MECKLENBURG COUNTY
Land Use & Environmental Services Agency

MEMORANDUM

To: Charlotte-Mecklenburg Planning Commission
From: LUESA, Mecklenburg County
Date: 8.25.22
Subject: Rezoning Petition Comments

2022-052: 6112 Tuckaseegee Road

SHEET NO.
RZ-1

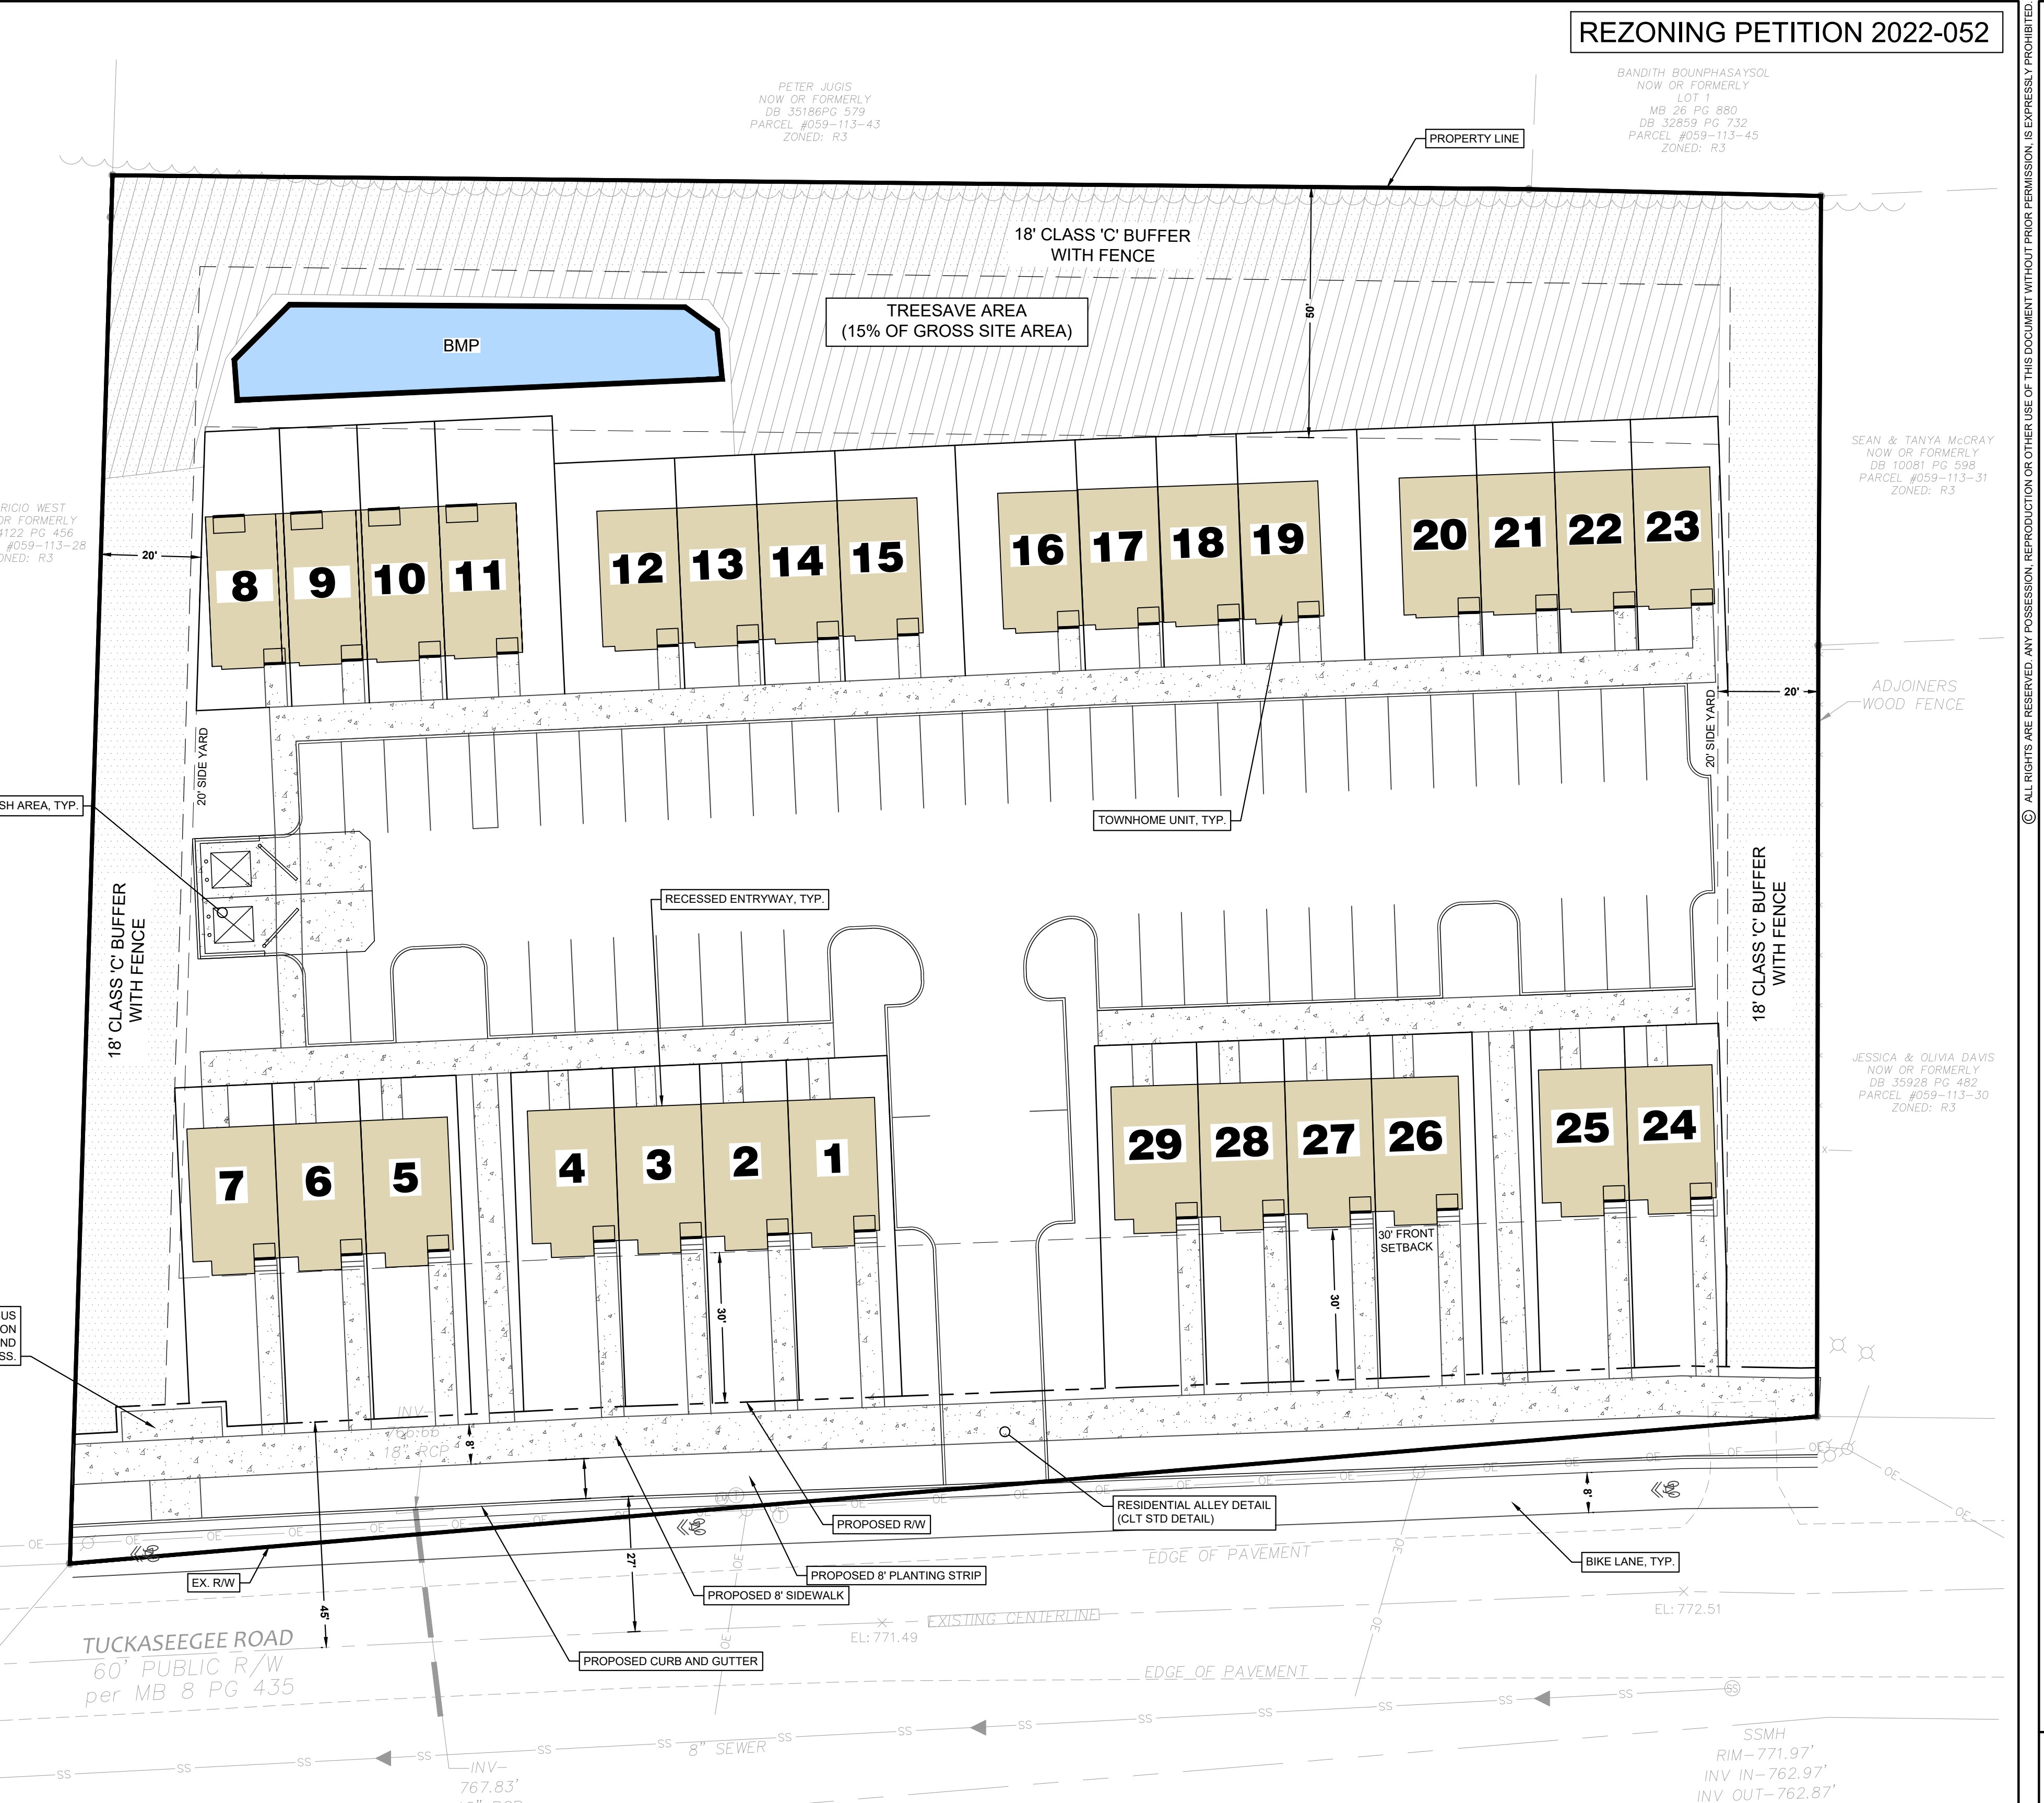
Air Quality Comments: The proposed development is planned to serve a multifamily/community/office group and to have vehicle parking greater than or equal to 20 spaces. Mecklenburg County Air Quality recommends that the proposed development be constructed with at least 10% EV-ready parking spaces. EV-ready spaces are those that have pre-installed electrical panel capacity with a dedicated circuit, raceway with conduit, and either a junction box or 240V outlet.

Information from property records does not indicate the current use of oil heat, but since records indicate structures were built in 1948, the property may contain an underground or above ground fuel oil storage tank. Any existing tank and its contents should be removed, following applicable NCDEQ guidance, prior to any demolition or grading activity.
